Fr: Simon Davis
Sent: 06 October 2014 14:17
To: 'Peter Champion'
Subject: RE: BR/71/12 - preparing NMA & DOC applications

North Elevation (front)

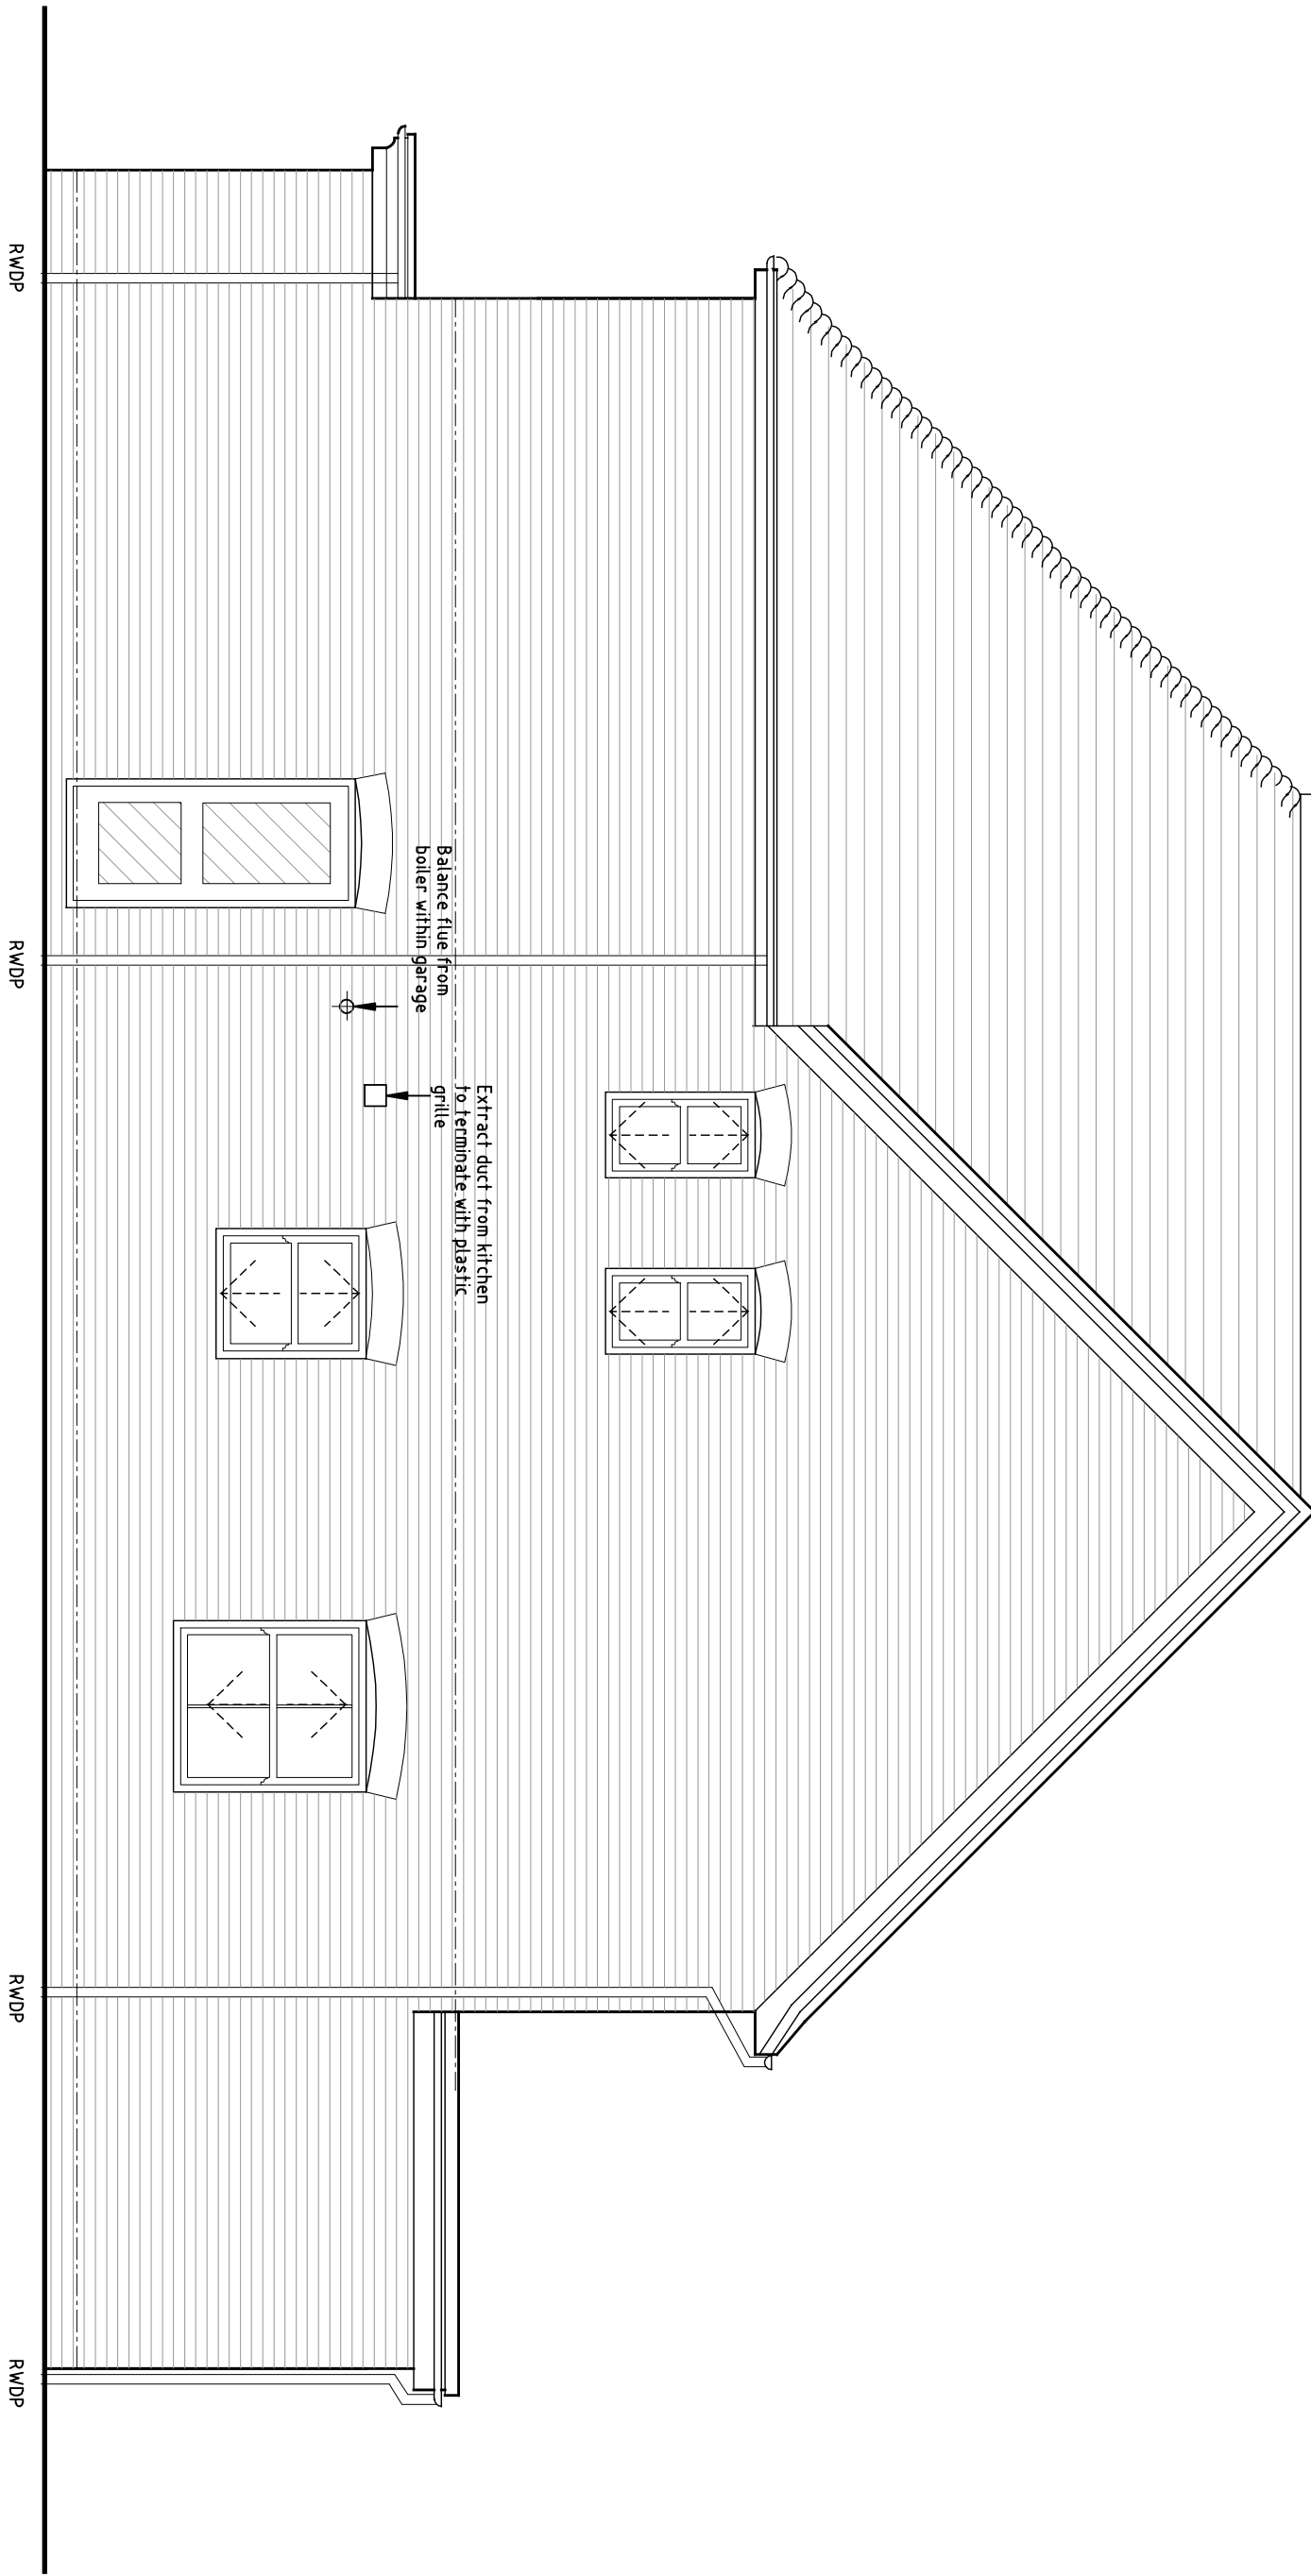
③ ~~TZ EXTENSION~~ TO 1m EXTENSION TO REAR OF PLOT 4 TO MATCH 1-3: IMPACT ON SANDY COODE? *

④ ROOF OF REAR 'EXTASIONS' TO BE FLAT WITH SINGLE CANTILEN:

LD OK AS REDUCES IMPACT ON SANDY COODE.

⑥ Δ CASE OF PLOTS 4+1 TO HIPPO: OK NO OBSERV.

* BUT WITHIN 1m DISTANCE AND
LESS IMPACT DUE TO Δ FROM PITCHED
TO FLAT ROOF.

SUBJECT
Site Layout Plan and Location Plan

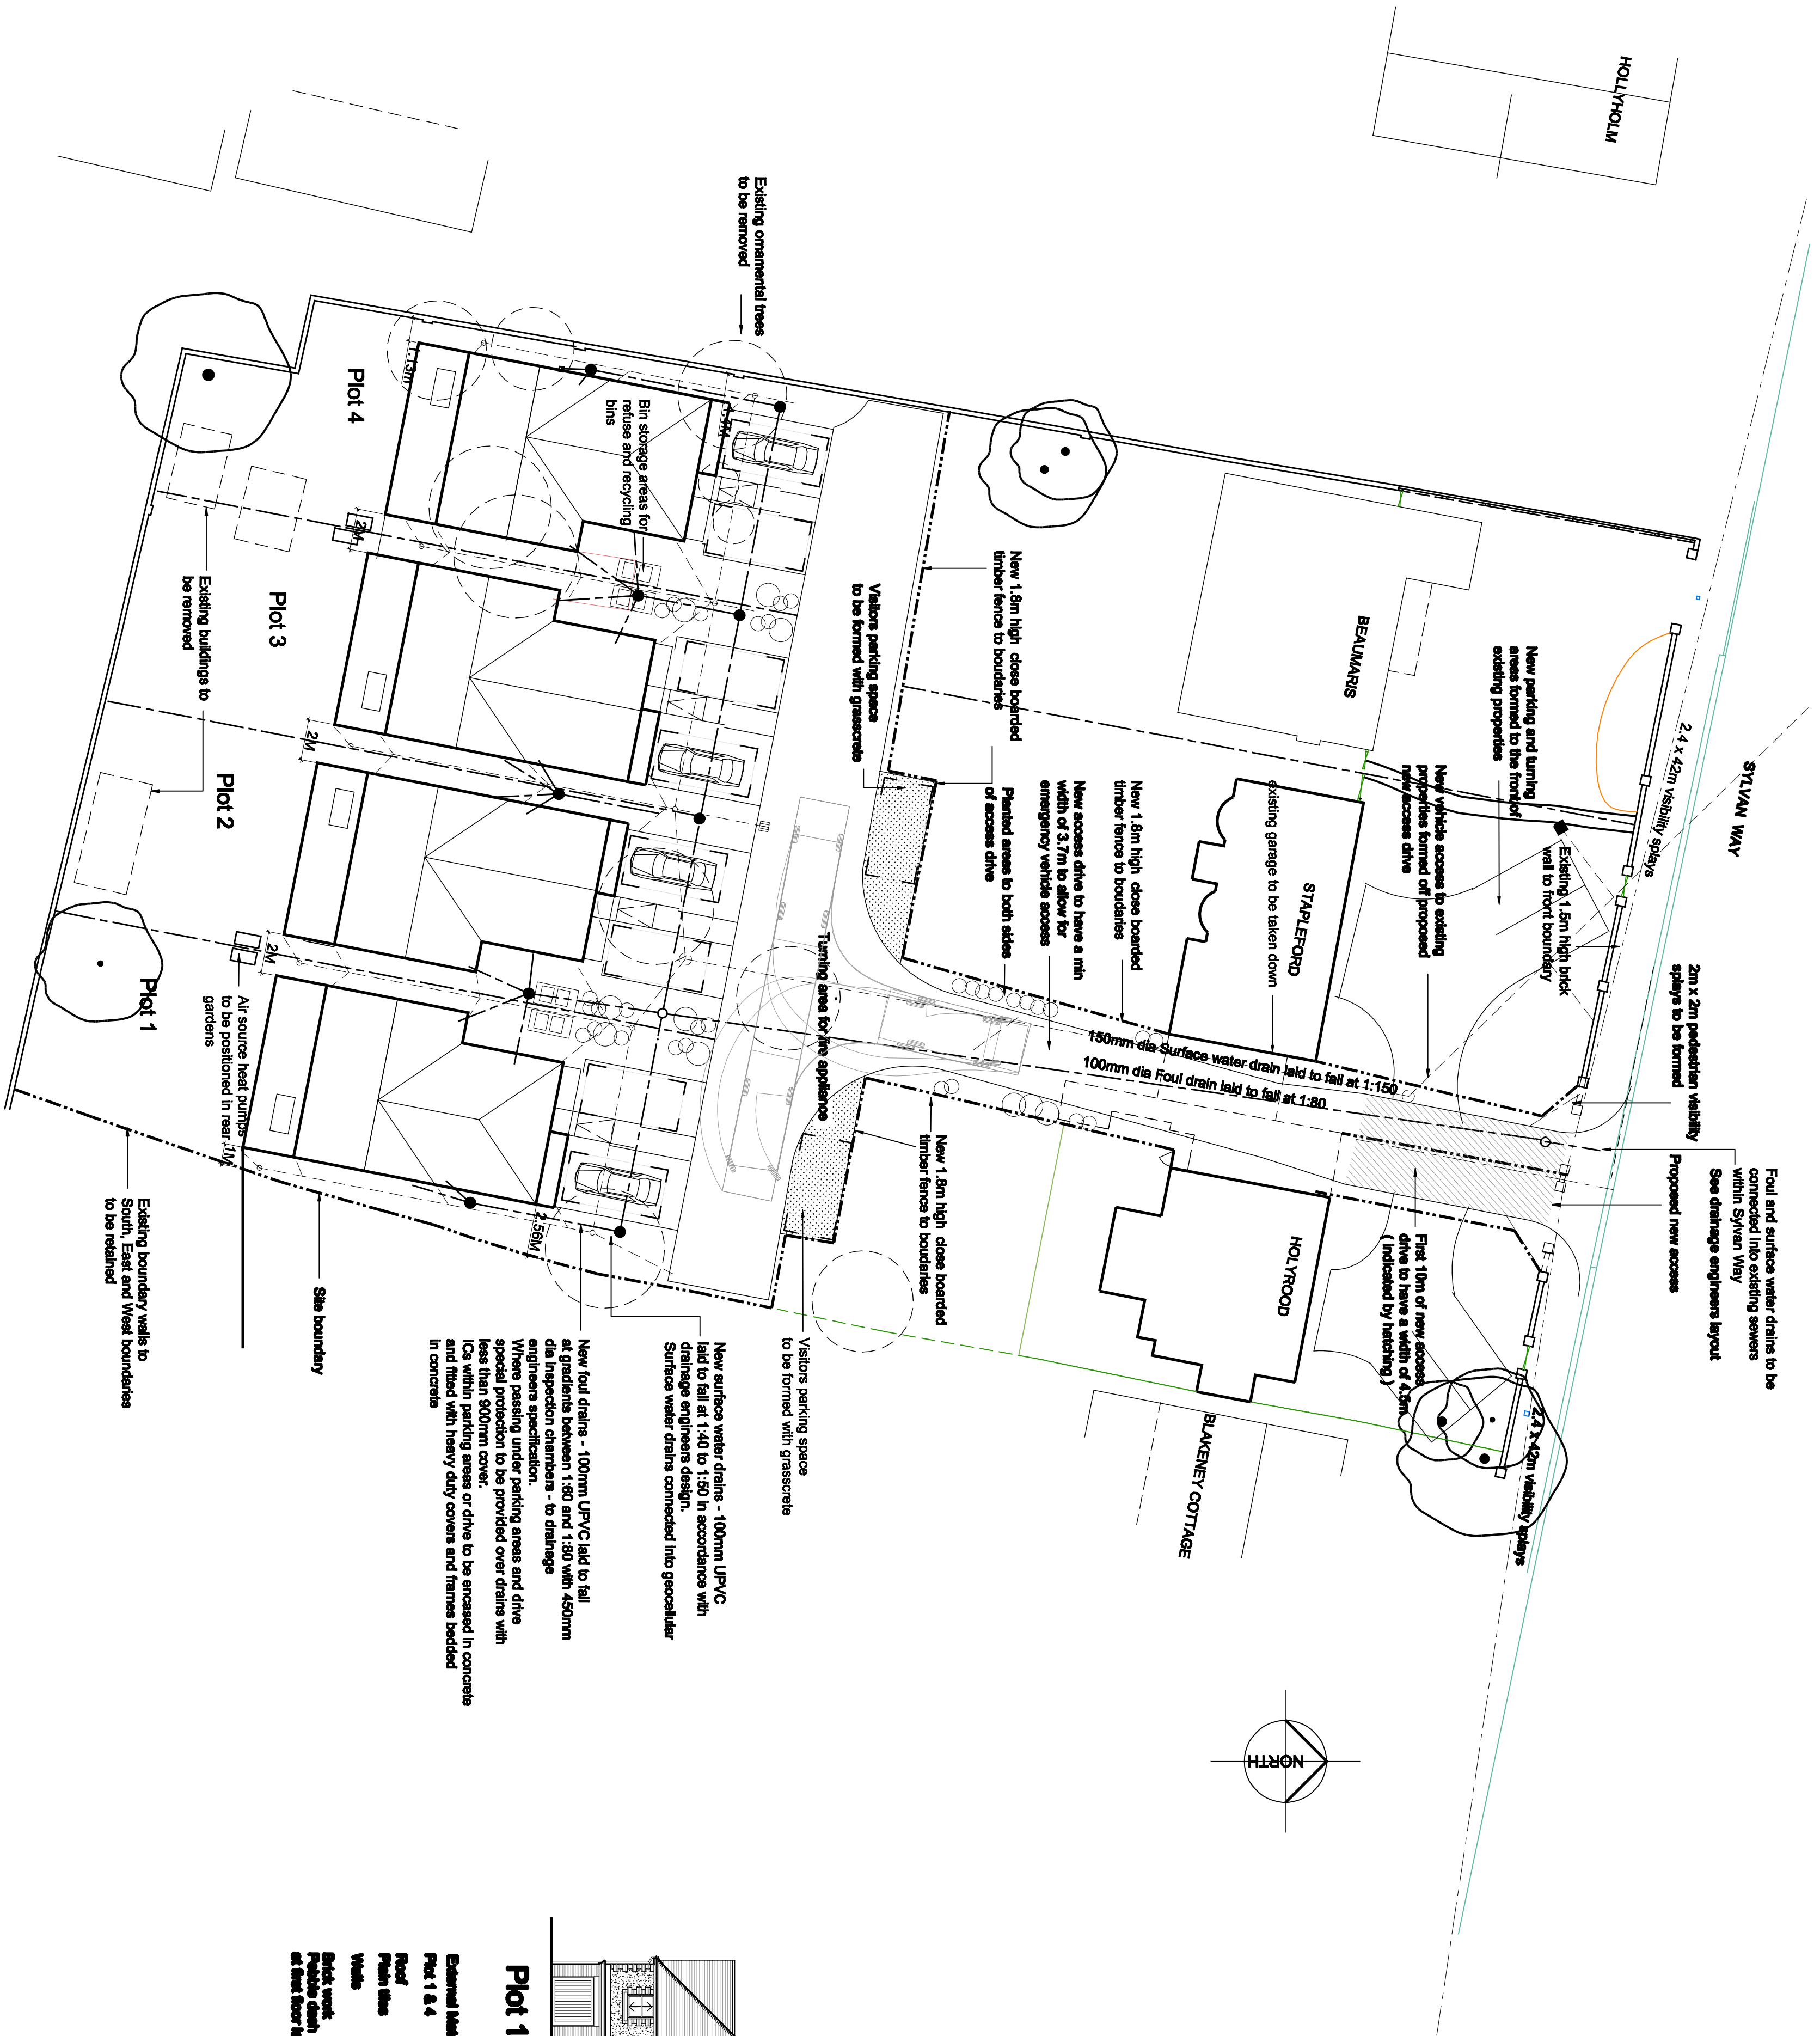
② Δ TO ACCESS TO REAR: OK.

SUGGEST Δ TO USE REAR SPACES: ~~FOR A BETTER TREE~~ (ONE COULD TO TREE TO BE ^{REMOVED} ~~REMOVED~~)
